# CITY OF ALBUQUERQUE

February 2, 2017

**RE: The Varela Residence Volcano Cliffs Unit 18  
6505 Pato Rd NW, S.A.D. 228, Lot 21 Block 6  
Grading and Drainage Plan  
Engineers Stamp Date 12/27/16 (D10D003M21)  
Pad Certification Date: 1/25/17**

PROJECT NO: 162055
DESIGNED BY: RJF
DRAWN BY: STAFF
CHECKED BY: RJF
DATE: DEC, 2016
SHEET TITLE: GRADING PLAN
SHEET NO: C-1.0

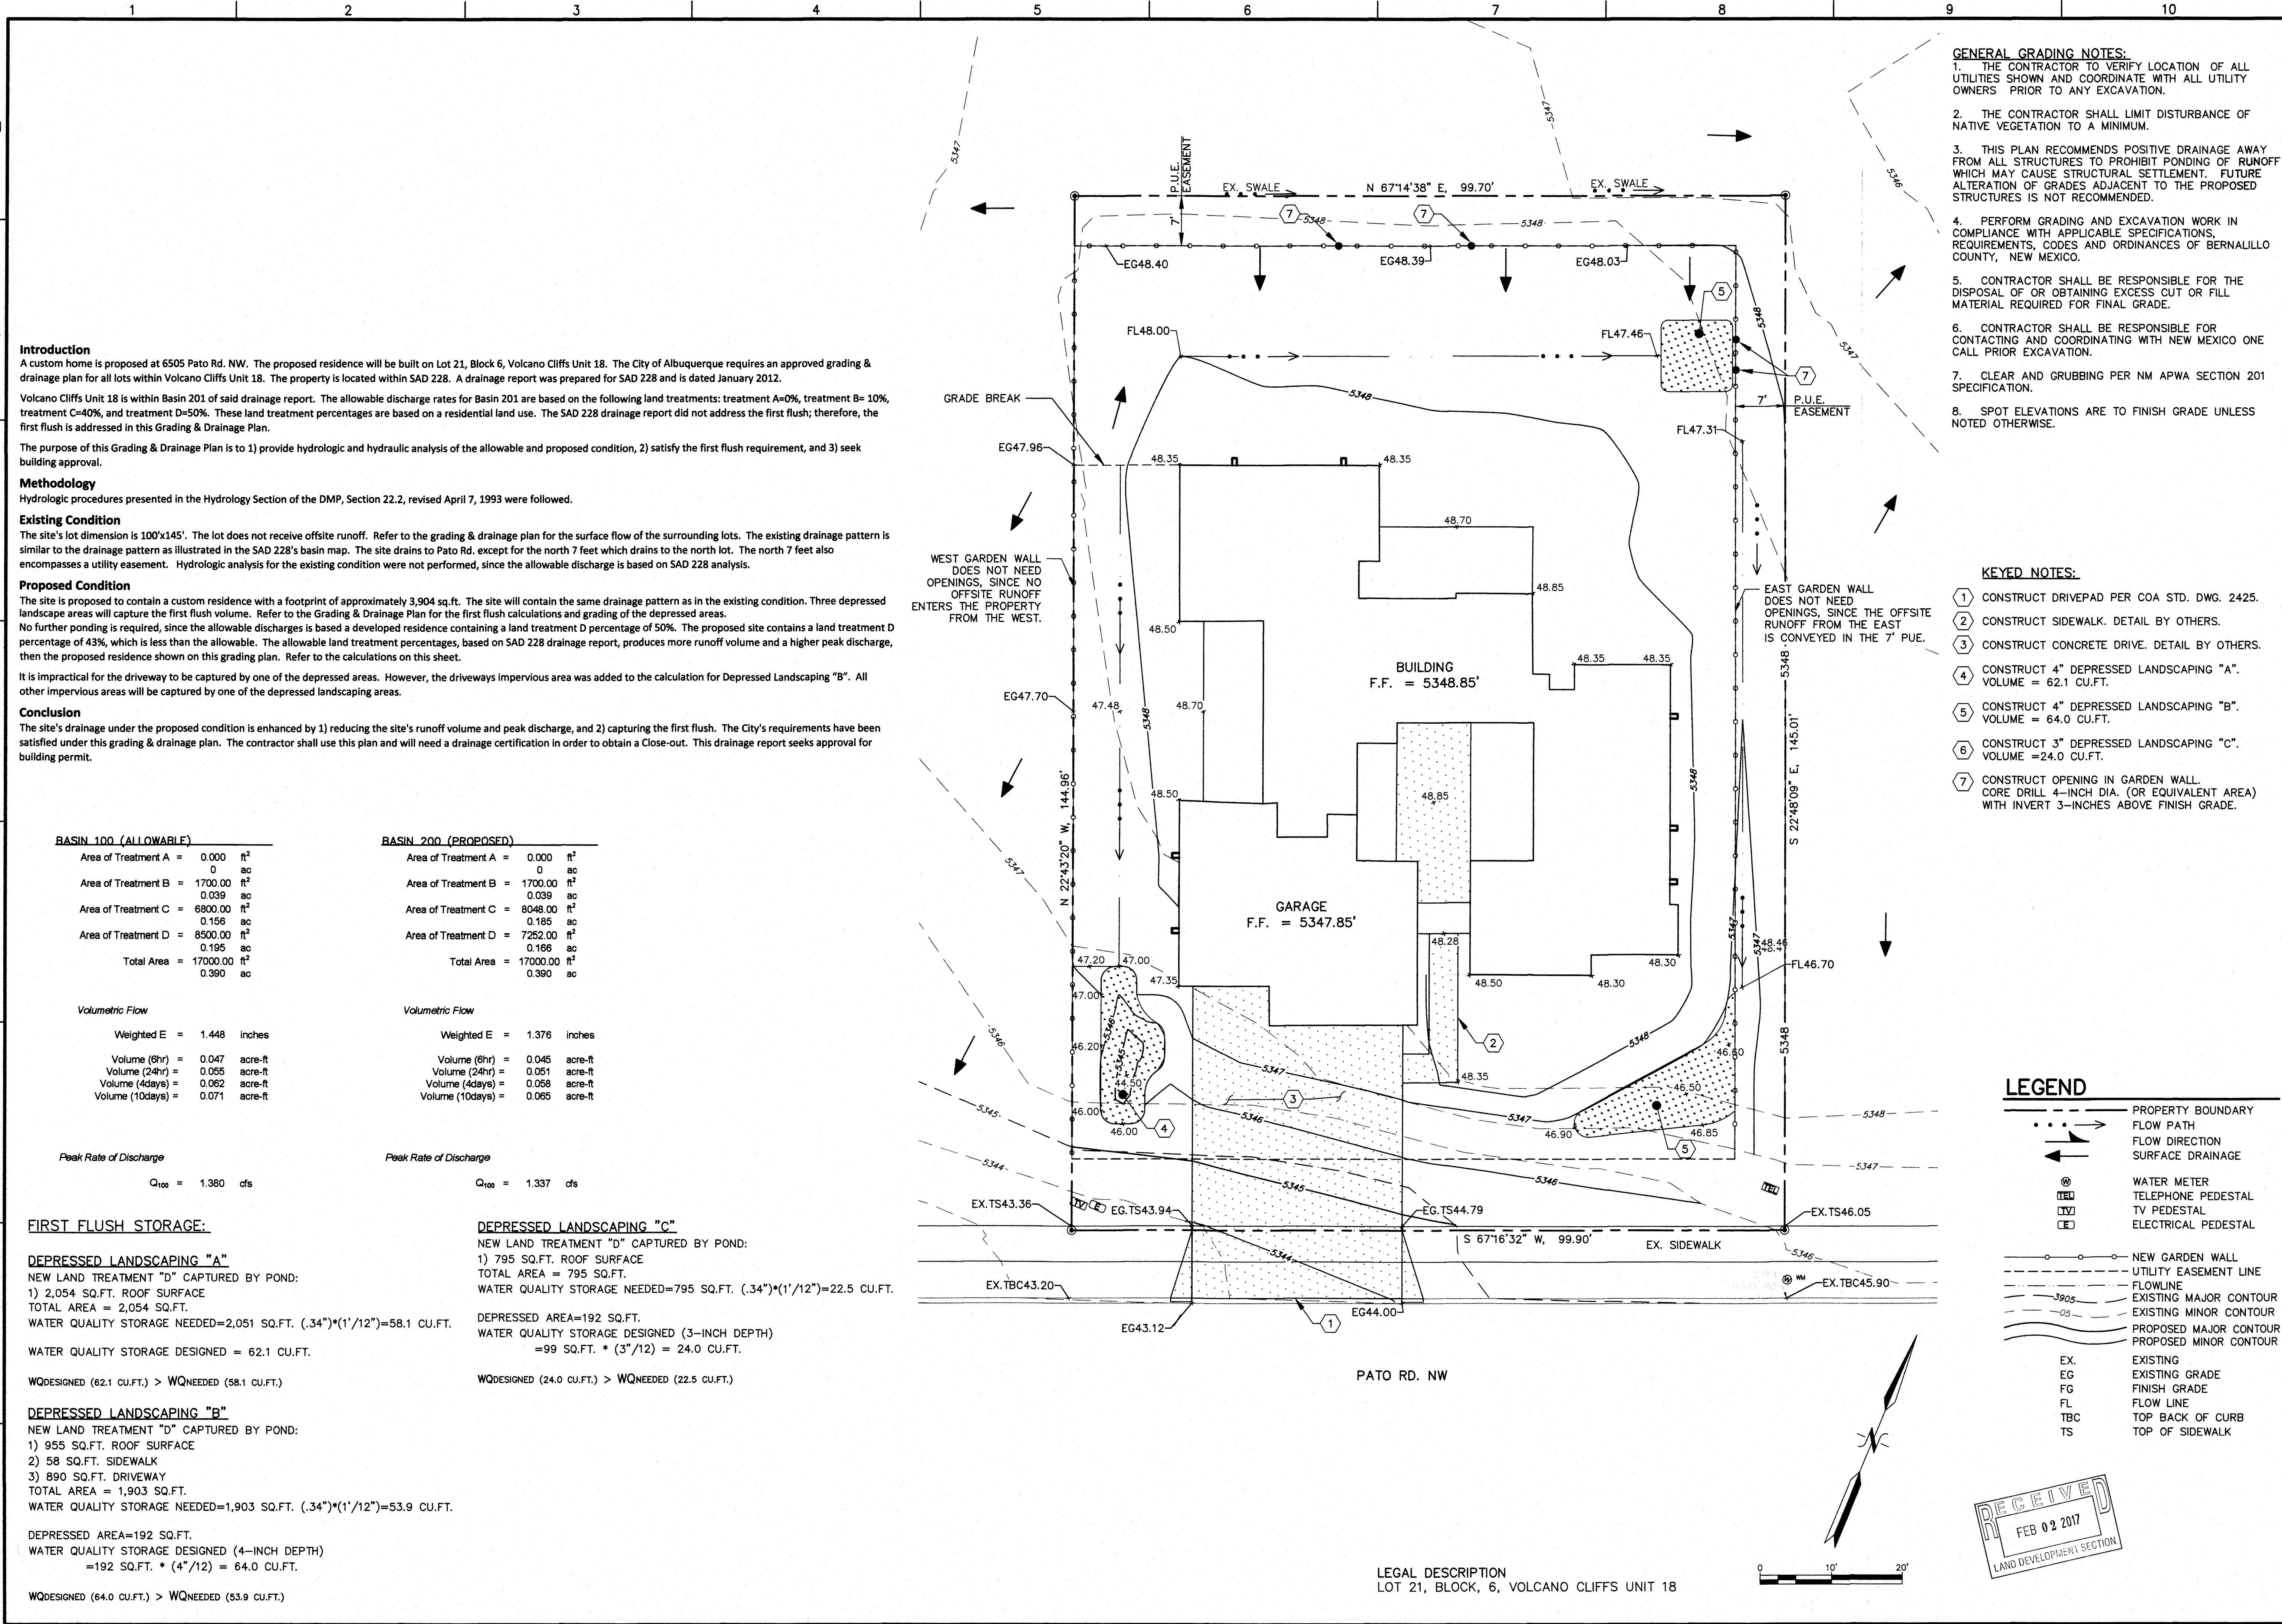
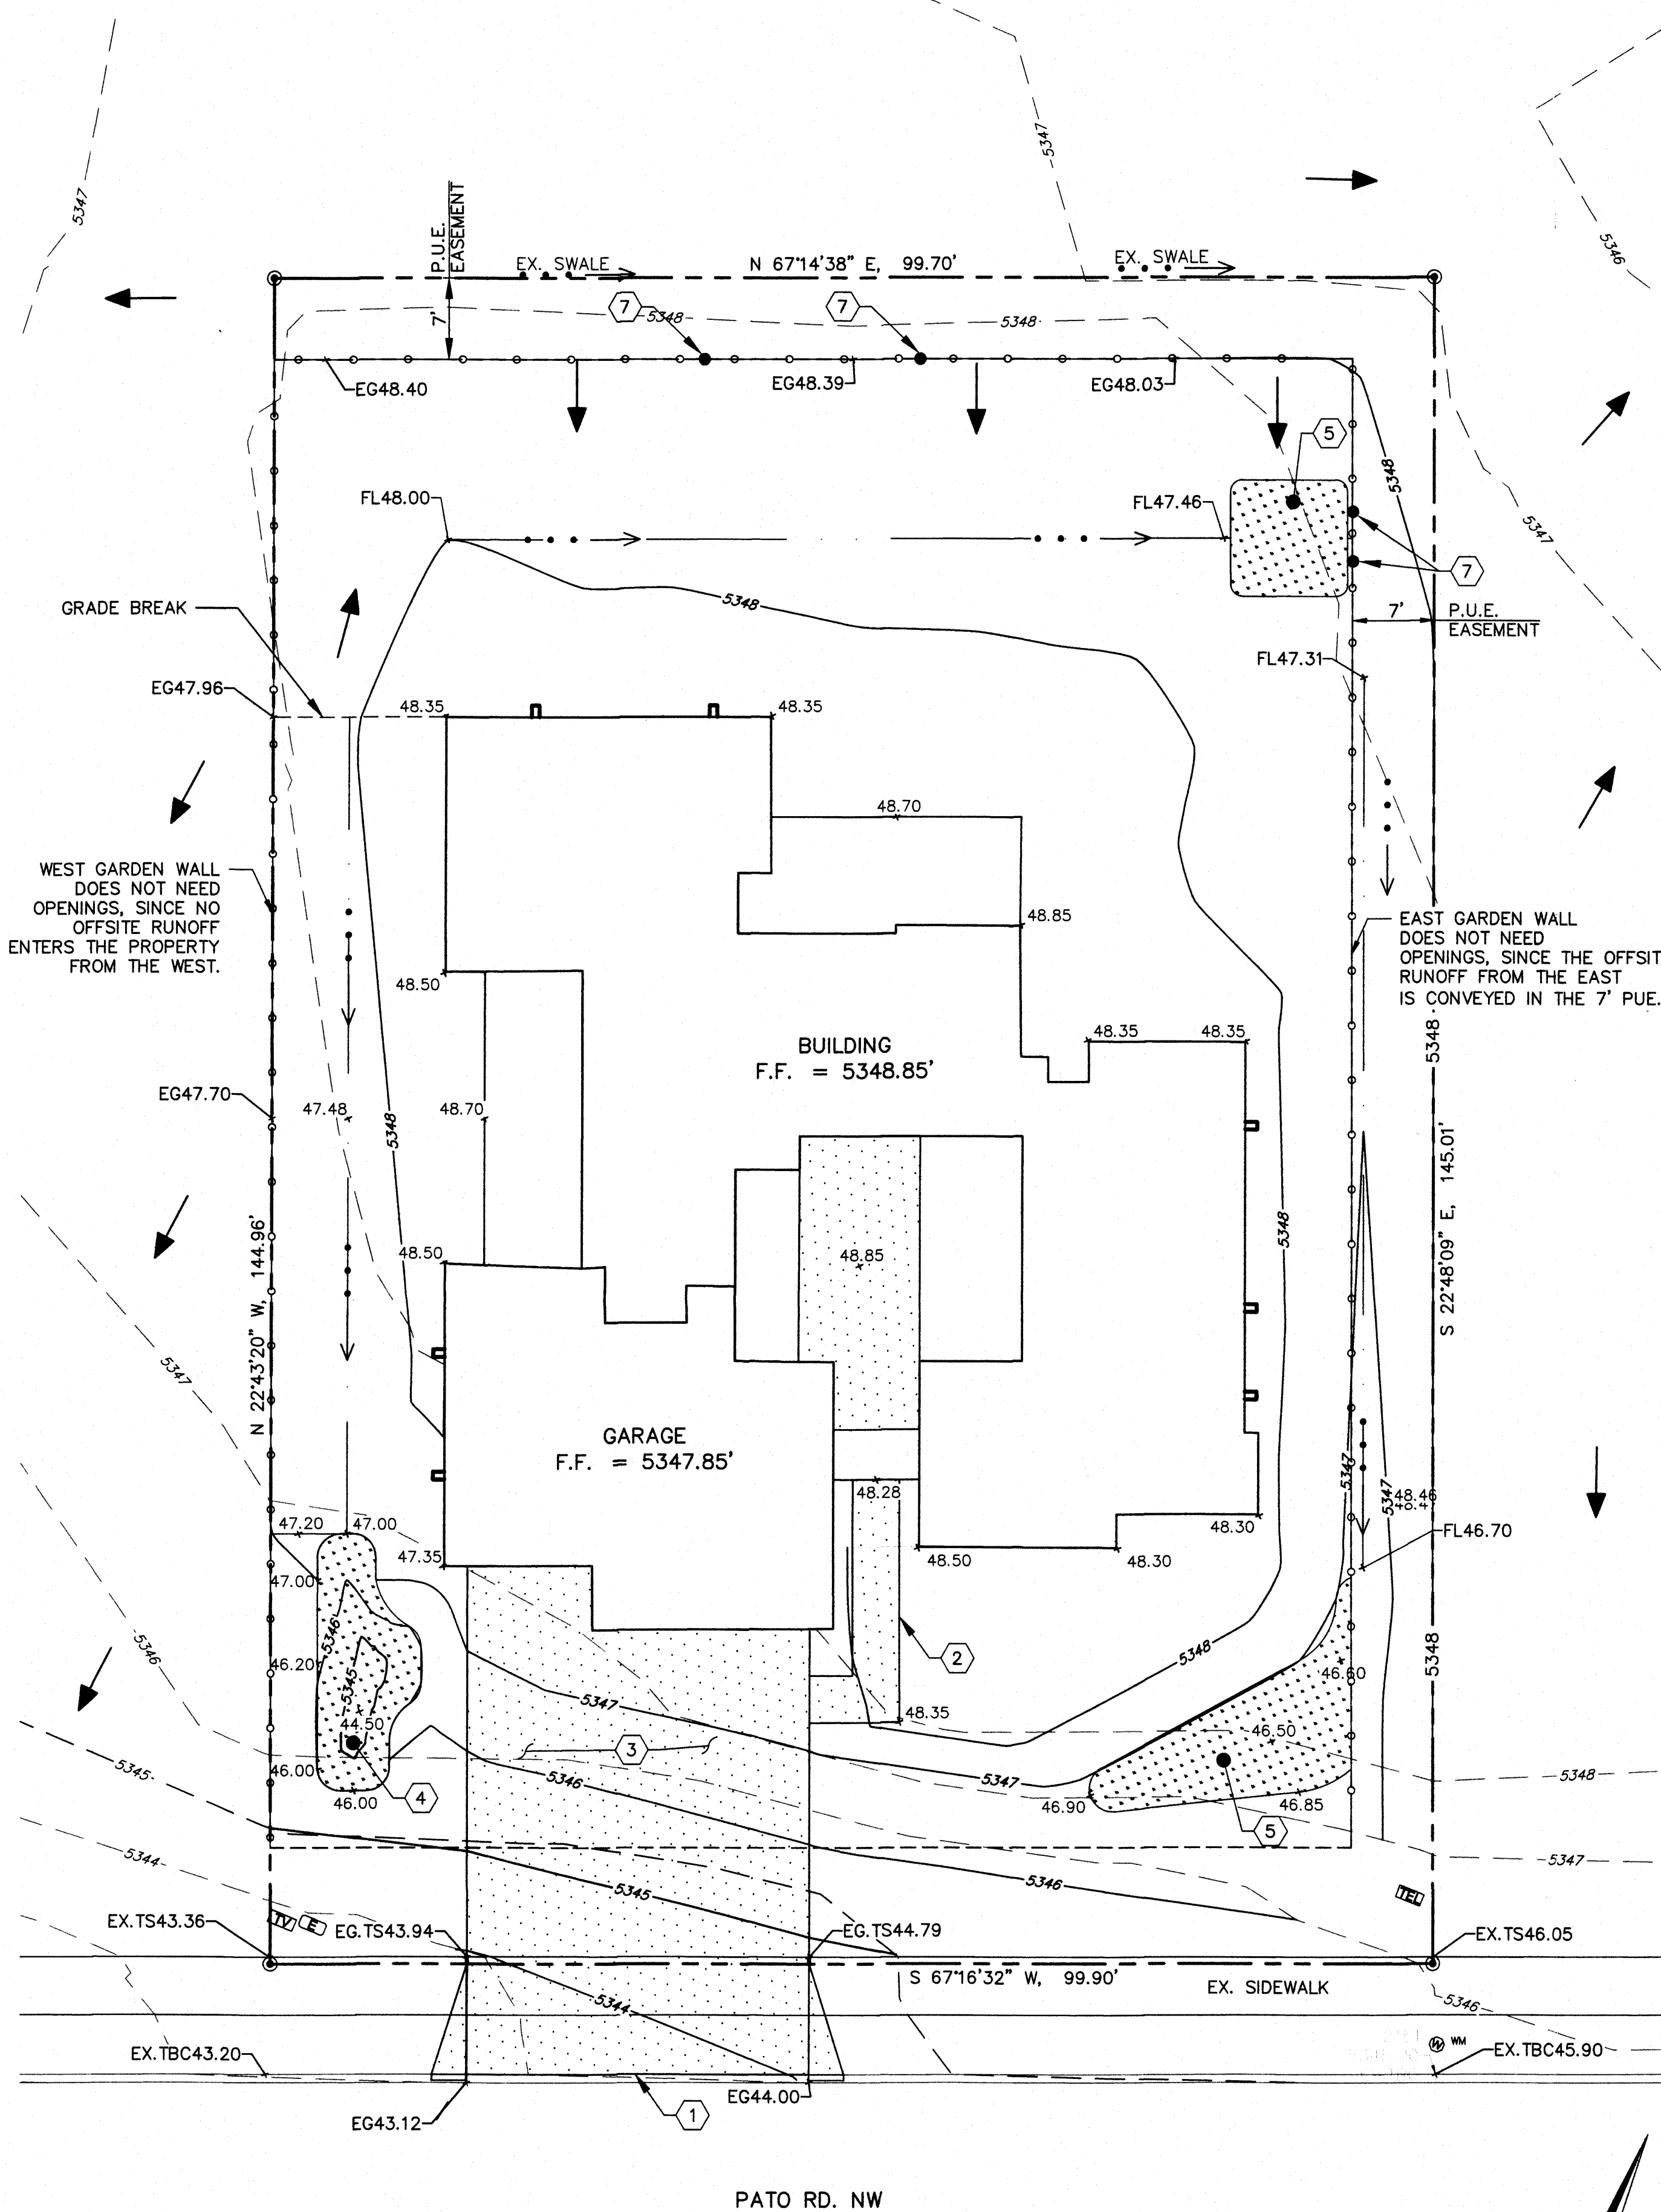
- Provide a statement requiring that a pad certification or a written statement by you is required before the home is released for building permit or the concrete pad is poured.
- Provide a statement informing the owner/contractor that a separate for a garden wall or retaining wall is required, and an opening 3" above grade is required for flows to pass through their rear yard according to the S.A.D. 228 master plan.

I have also met with the contractor and informed him of the revisions made on the Drainage Plan sealed 1/25/2017. The contractor understands that the North garden will need two openings that are each equivalent to a 4-inch dia. and 3-inches above the finish grade. The West garden wall will not need any openings, since there is not offsite runoff coming from the west. Also, the East garden will only require an opening to drain the site's back yard to the 7-foot PUE easement. Any offsite runoff from the East will be conveyed within the 7-foot PUE easement.
